Planning Application: R/267/17/PL

Objection to Application no: R/267/17/PL

Rustling Hall Nursing Home

Amended plans to lowering roof height by 1m.

SITE SECTIONS

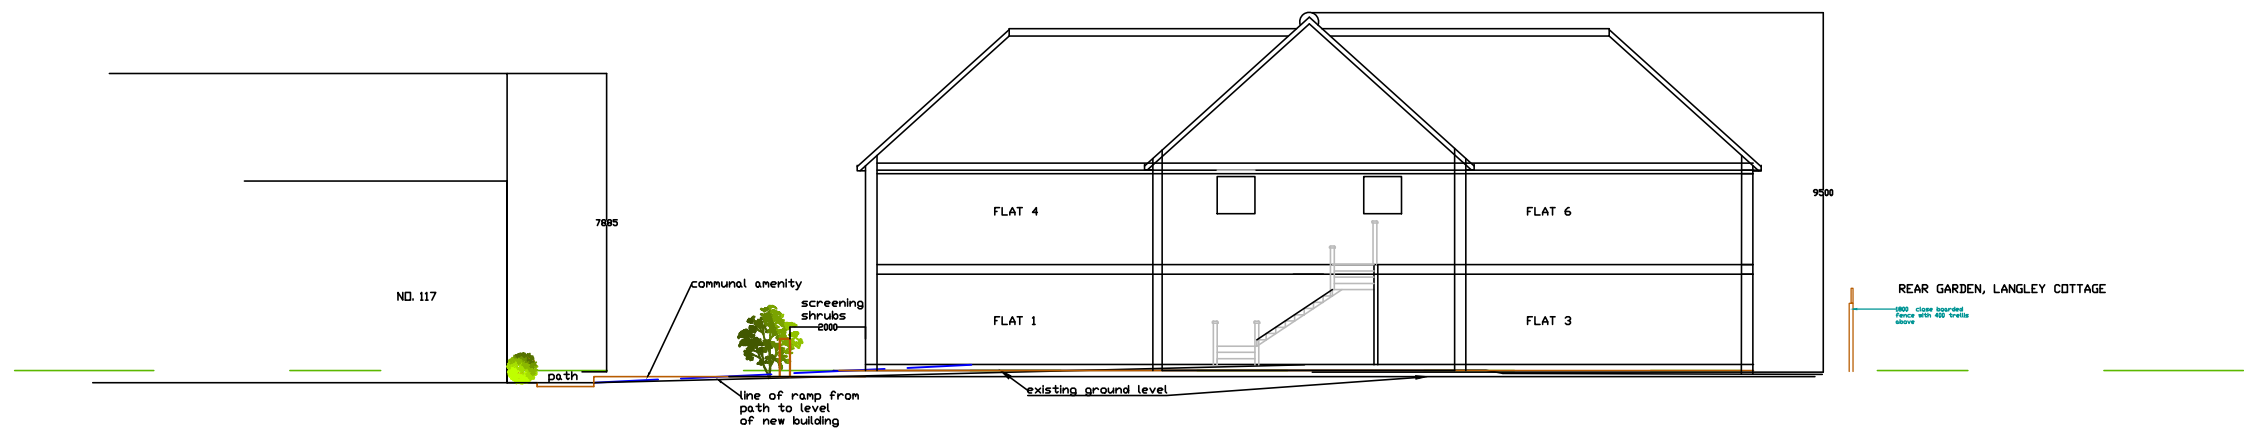
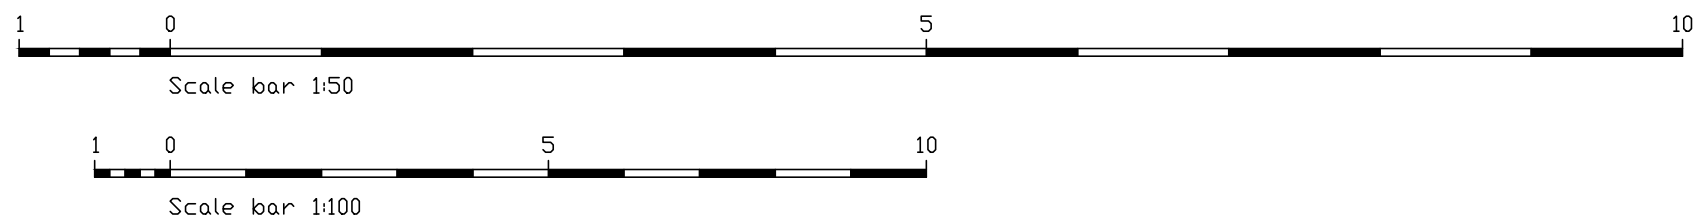
The alteration to the above construction plans reducing the roof height by a metre is just a token gesture not addressing the effects that neighboring properties in Paddock Green will suffer; namely that the construction, by still being so overbearing and intrusively close, will impede light and sunlight from the Paddock Green houses and their small garden havens. When the houses in Paddock Green were built their overall height and the location of windows etc. were not an issue as there were no neighbours to over-look and as such the height of these older properties and distance from the boundary should not be used as a guideline for new construction. Why does the proposed building still need such a deep internal roof area?
